Consultation Response from Emma Mills
KC Landscape

Application No:	2021/93621
Proposed Development:	Erection of 12 dwellings (previously 10) and associated works (Within a Conservation Area)
Location:	Land off, Fullwood Drive, Golcar, Huddersfield, HD7 4JH
Applicant/Agent:	Acumen Architects
Planning Officer	Ellie Worth
Date Responded:	27.03.23
Responding Officer:	EM
Responding Ref:	KK119

Appendix 2: Draft tree protection plan

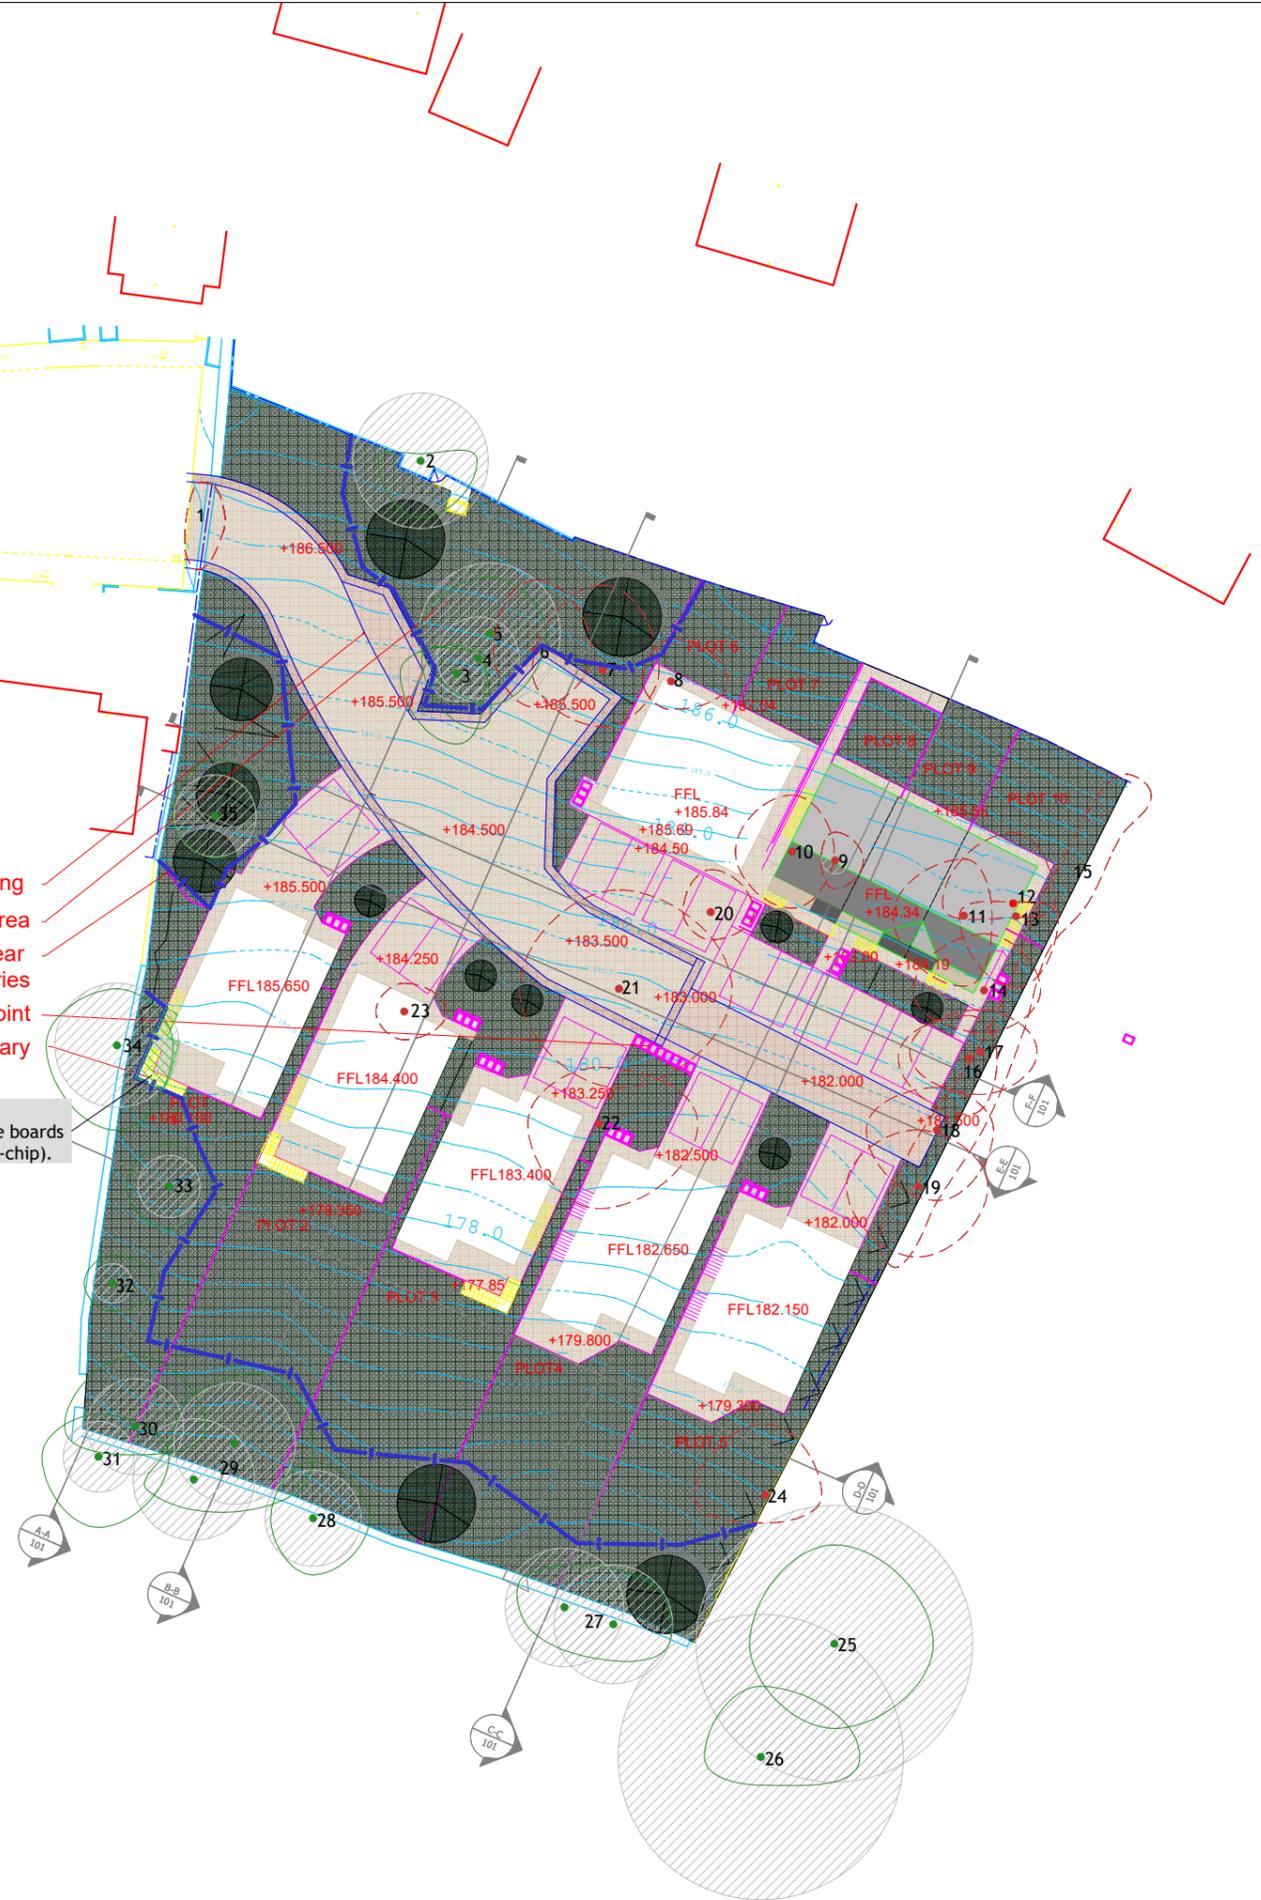
Wildlife and habitat networks, TPO's, PROW : links & connectivity: New developments are to retain and incorporate existing significant trees within the layout as stated within Kirklees Local Plan policy LP33. WHN and TPO tree belt close to the southern boundary of the site. Trees to the southern boundary are important for connectivity.

The woodland area adjacent the Site is designated as a Wildlife Habitat Network. The protection and enhancement of this area is required by a number of policies within the Local Plan, including LP30, LP31 and LP33.
